Application No: LU/35/26/HH
Site Address: 11 Fleet Close Littlehampton BN17 6SD
Description of works: Proposed two storey rear extension and single storey side porch and new windows to side north elevation.

OWPC82168

SIDE NORTH ELEVATION
PROPOSED ELEVATIONS

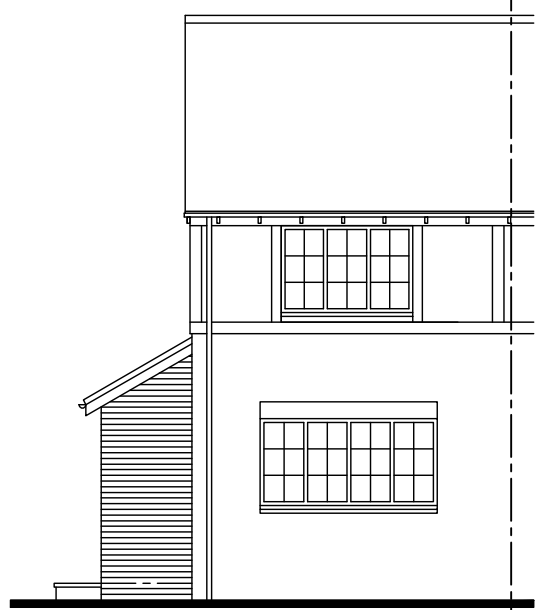
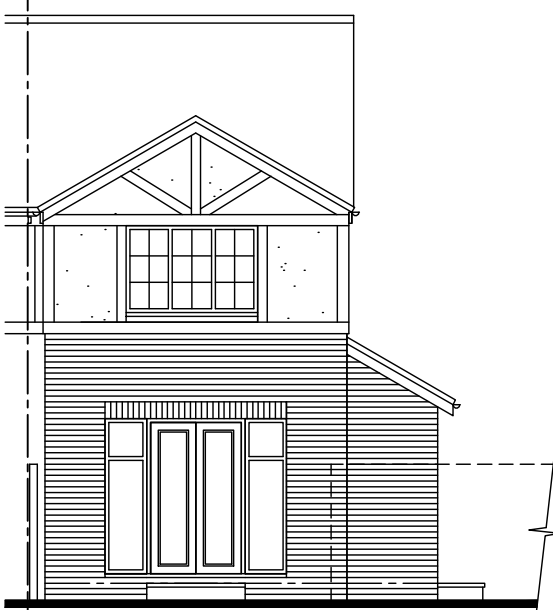
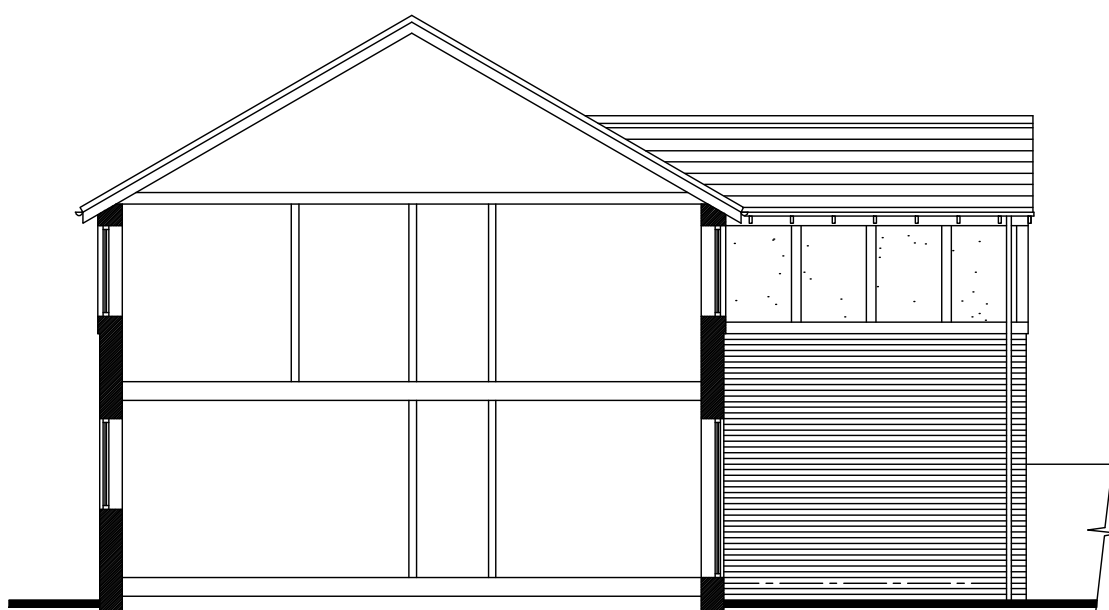
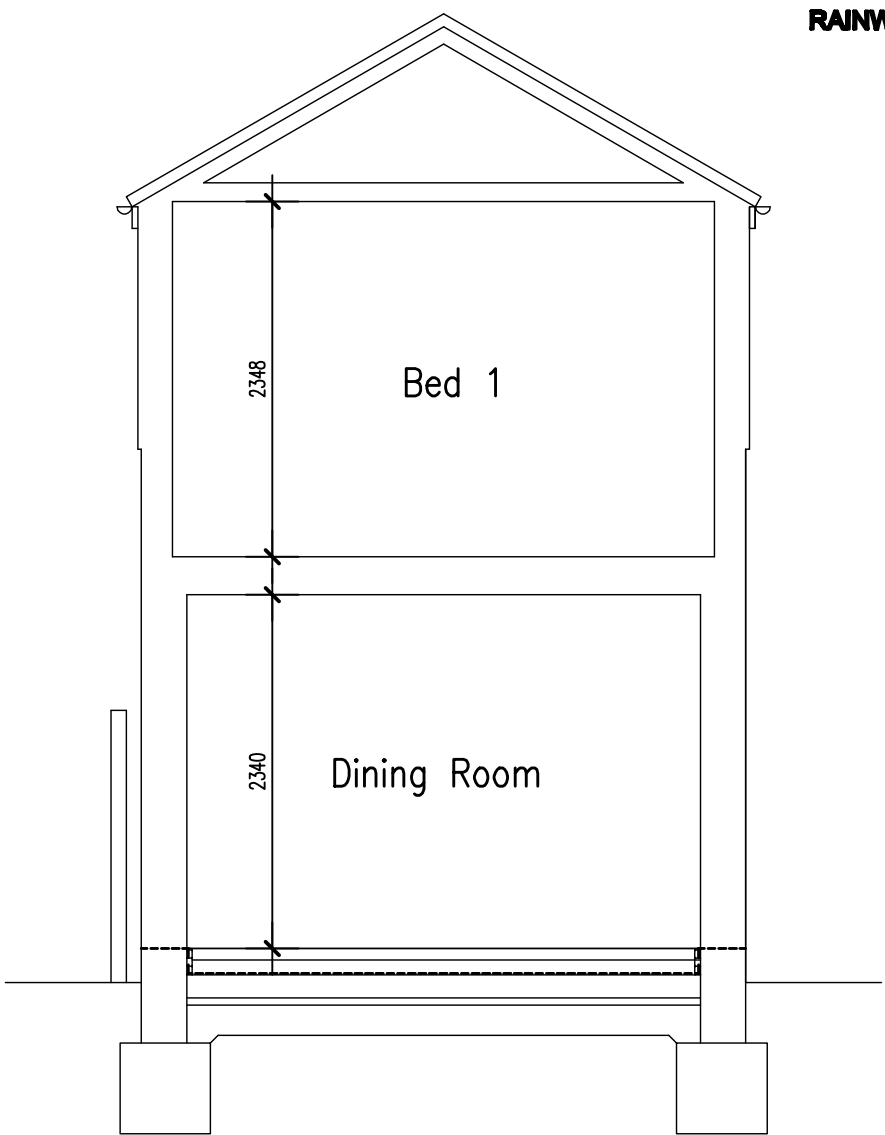
This application was considered by Littlehampton Town Council's Planning and Transportation Committee on 23 February 2026. The committee objected to the application due to overdevelopment and overshadowing. The proposed two story extension was seen to be over-bearing and out of scale compared to the neighbouring properties. Should the application be approved, members suggested the conditional addition of a swift box due to its proximity to reported swift nests.
